Matter raised during the Open Floor Hearing (OFH1 – 30th September 2022) by Boreham Parish Council (Cllr Linda Reed) relating to the increased levels of traffic on the 2 country lanes which are the only access routes to the proposed entrance of the Longfield Solar Farm.

WIDENING WITHIN HIGHWAY BOUNDARY
 ON NORTHERN SIDE OF CRANHAM ROAD
 (UP TO 1.55M ADDITIONAL WIDTH, OVER
 CIRCA. 230M IN LENGTH)

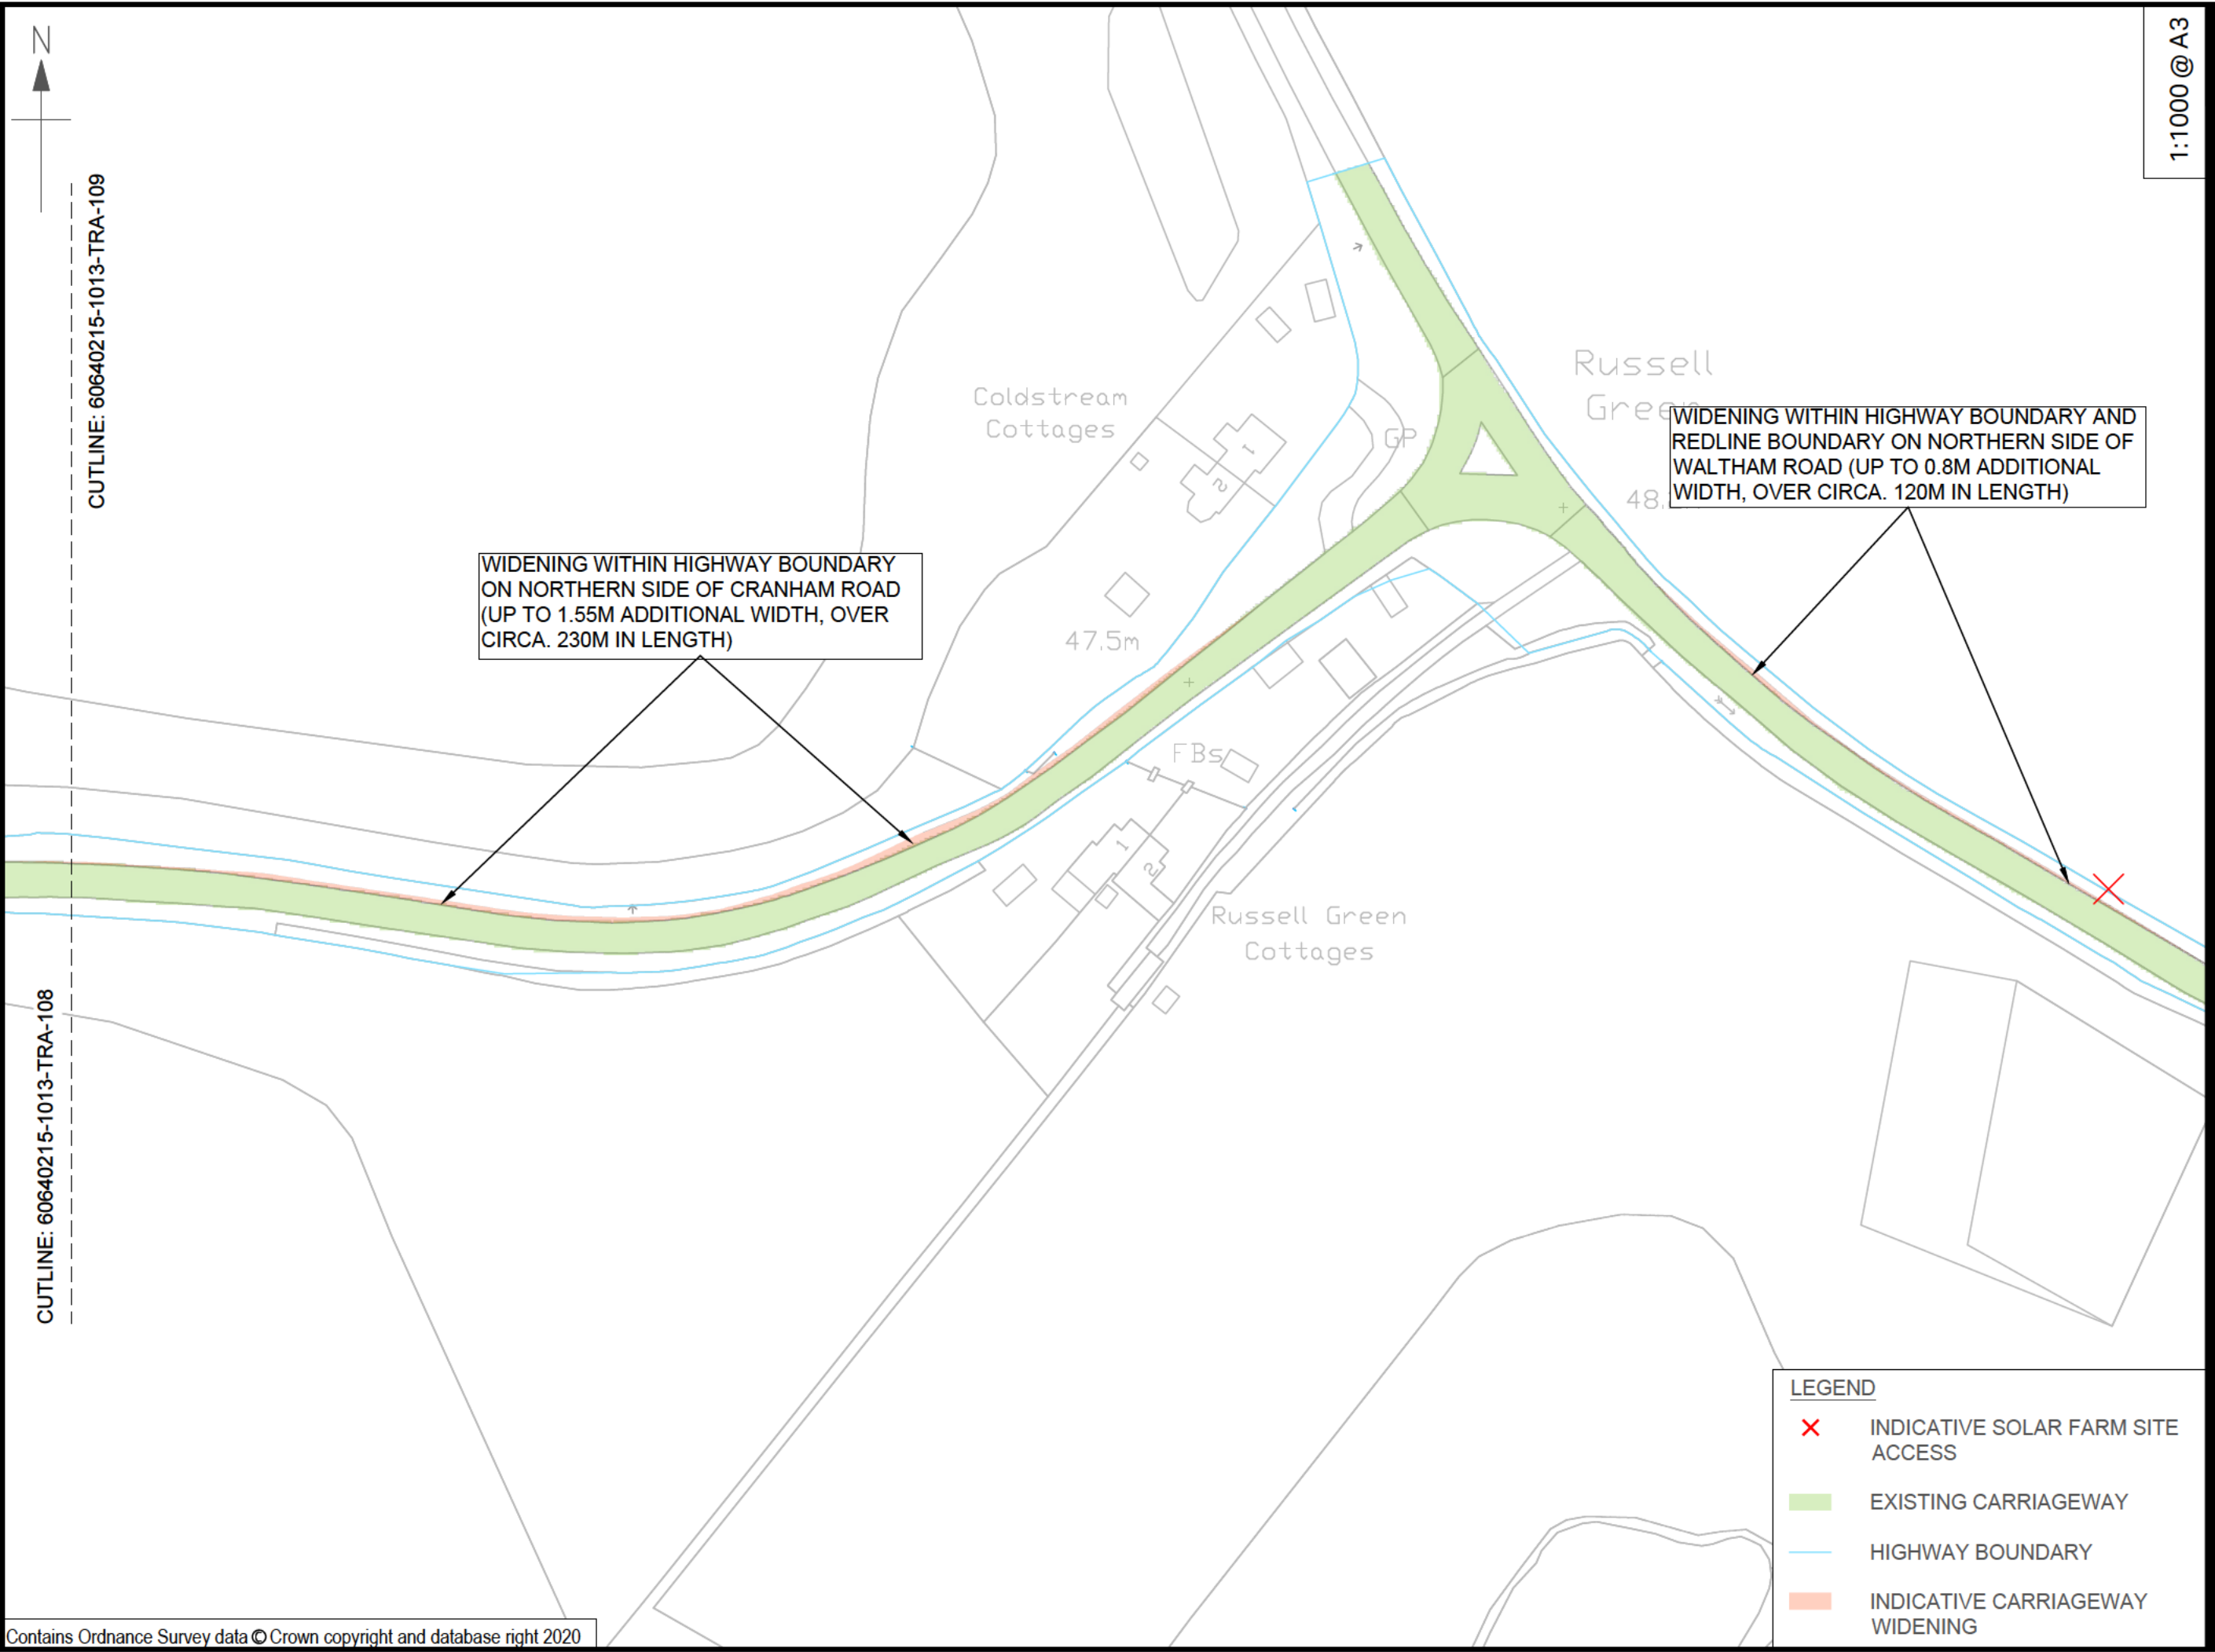
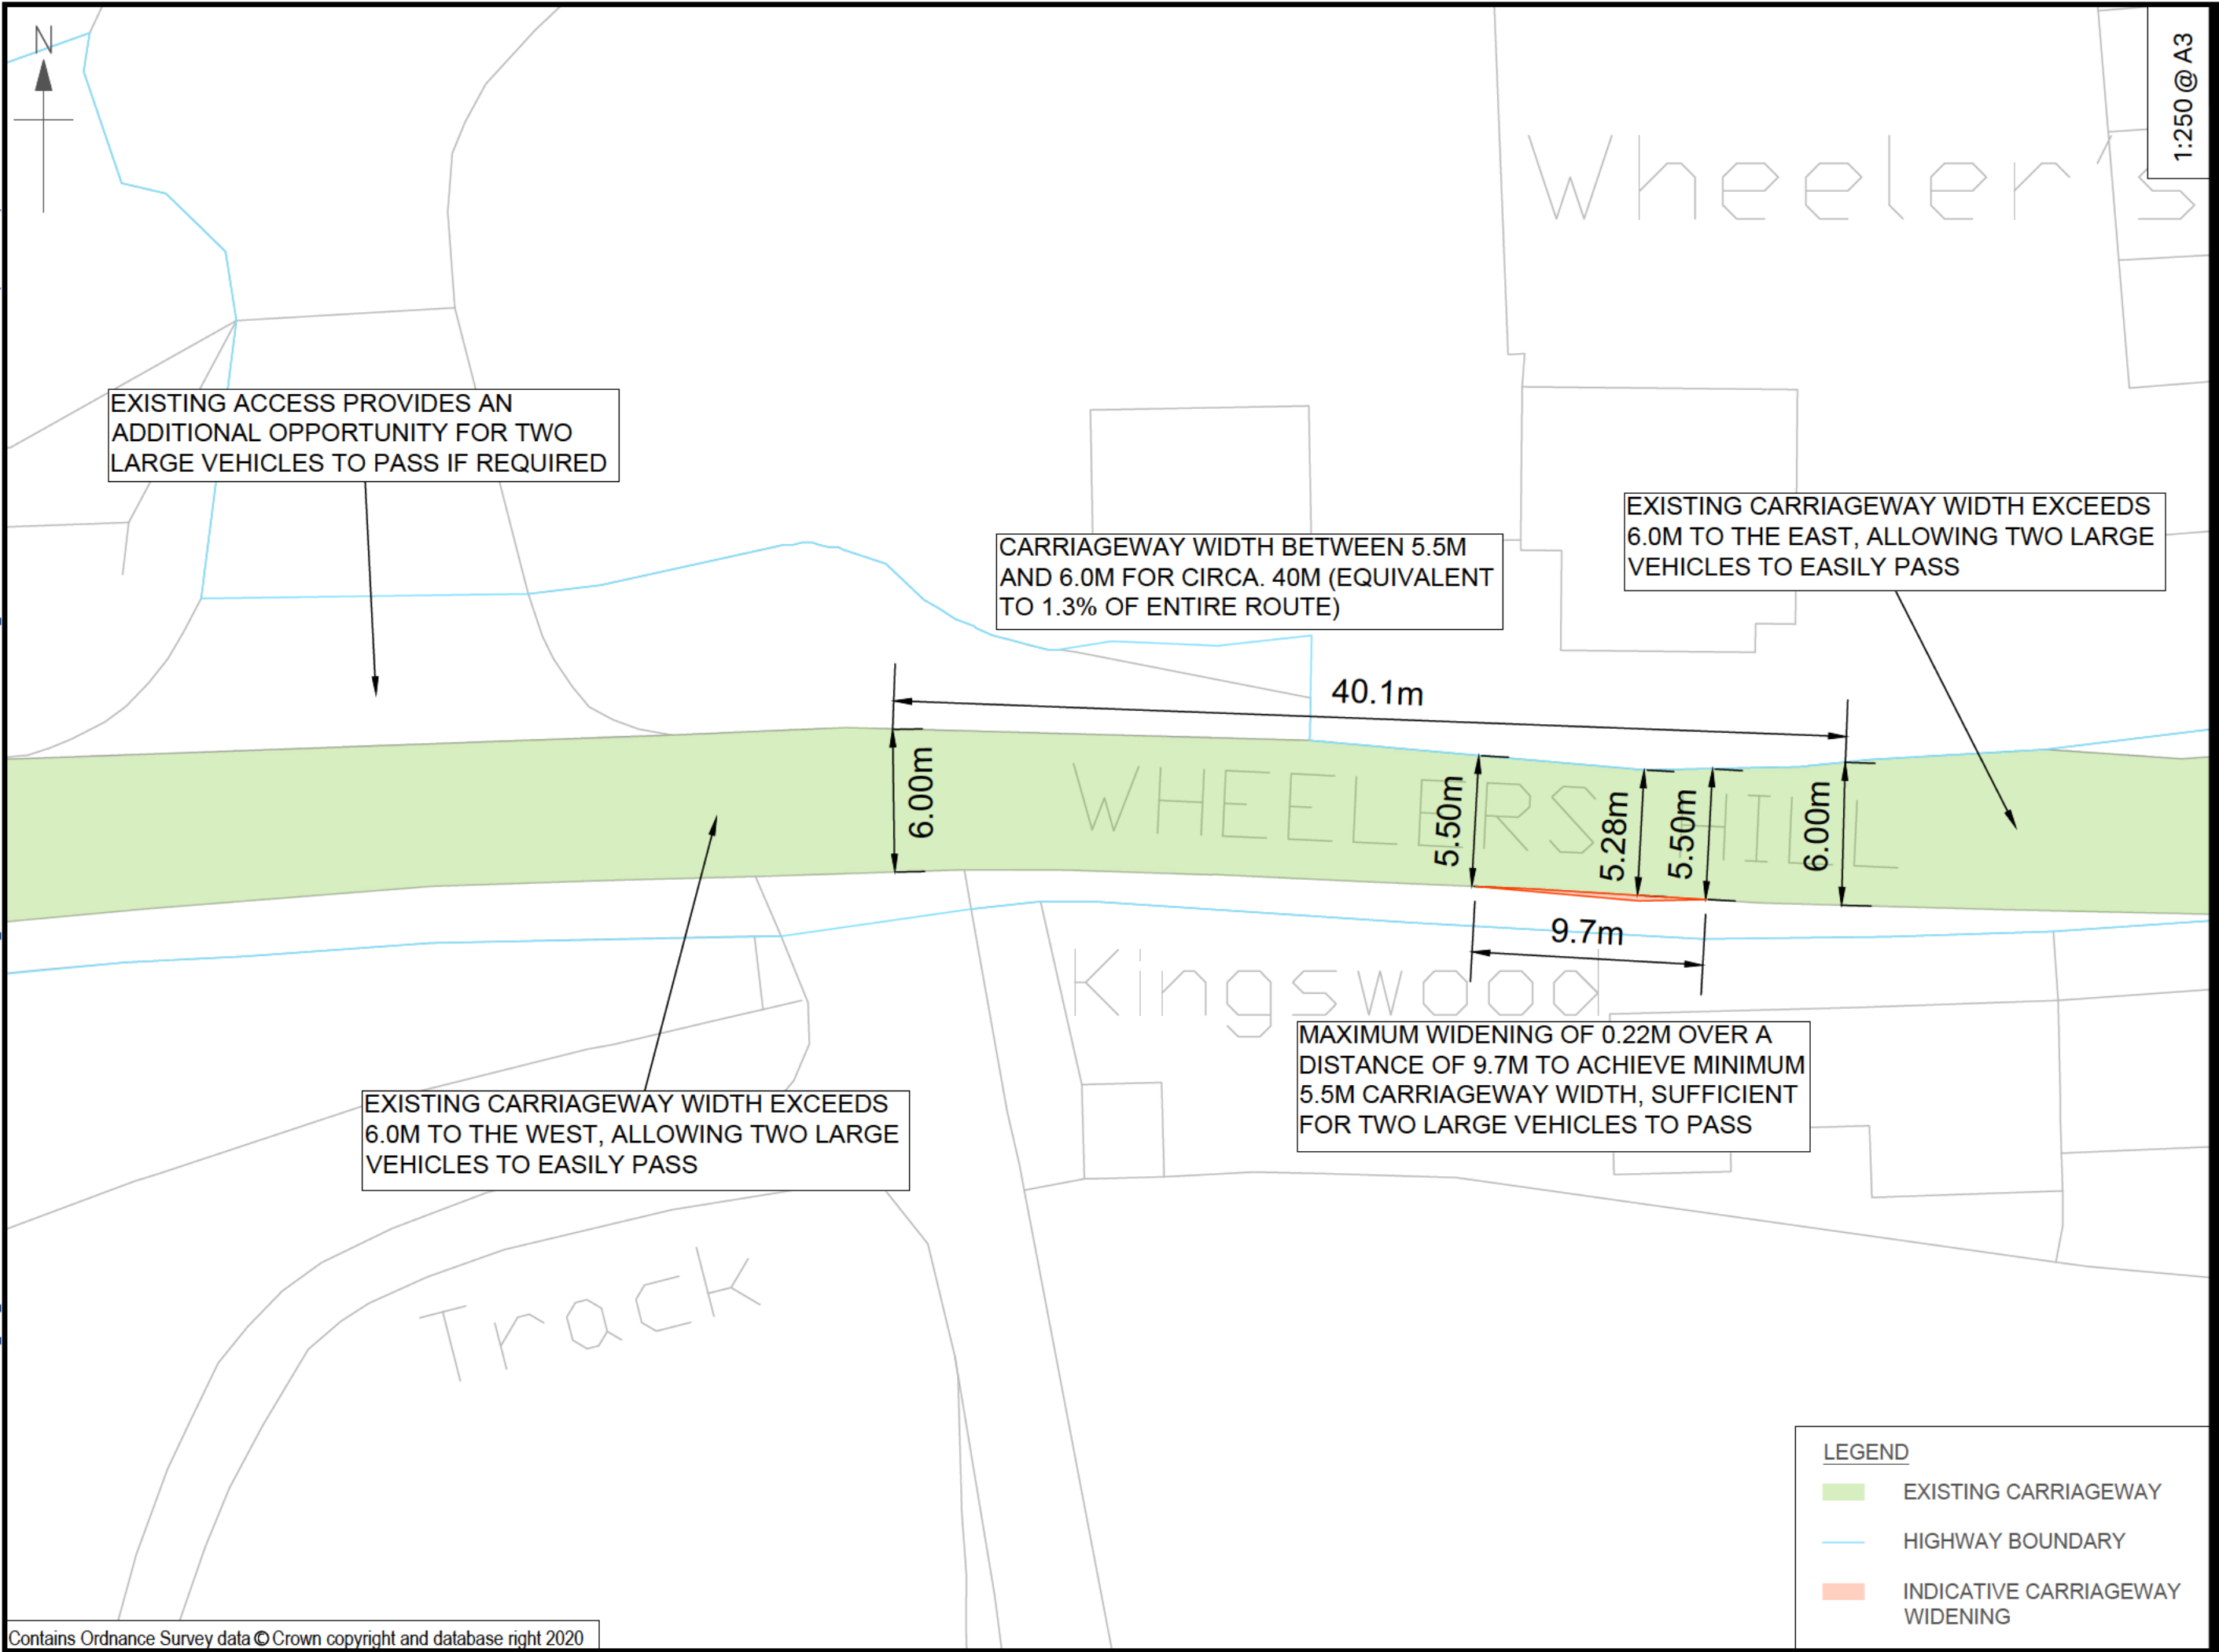
The developer's preferred route to the Longfield site is via Cranham Road and Wheelers Hill. This is country lane which, even following the proposed widening is not deemed suitable for the type traffic anticipated during the implementation phase at Longfield. This route will also be impacted by the construction of the Chelmsford North East Bypass (CNEB). The only other route to the site is via Main Road, Boreham and Waltham Road. It is the stated intention of the developer not to use this route. However, it is likely that there will be times throughout the implementation phase and beyond where this will be necessary due to blockage, delay or temporary closure affecting the preferred route or other routes leading to it. These incidents do occur from time to time.
